Application # 0750017852R

COUNTY OF HARNETT LAND USE APPLICATION

Re: Status of Improvement Permit Application #07-5-17851 Lt 255 & #07-5-17852 Lt 256

**CUMBERLAND HOMES, INC.**  
**THE GRANT**  
**LOT # 256 CRESTVIEW**  
**SCALE: 1"=50'**

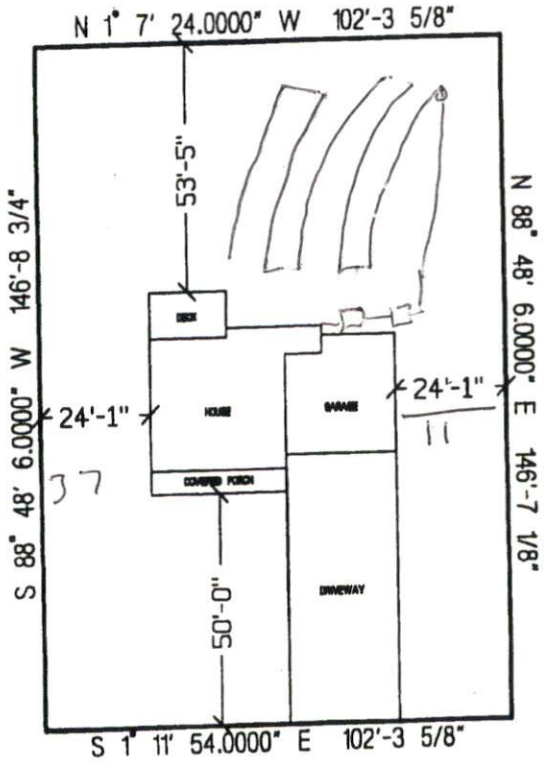
1. Property lines/corners not marked or labeled
2. House corners not marked or labeled
3. Directions not clear to property
4. Property needs brush or vegetation removed
5. Backhoe pits required
6. Other – Please move house sites as shown on attached sheet, and submit new plot plans to Central Permitting.
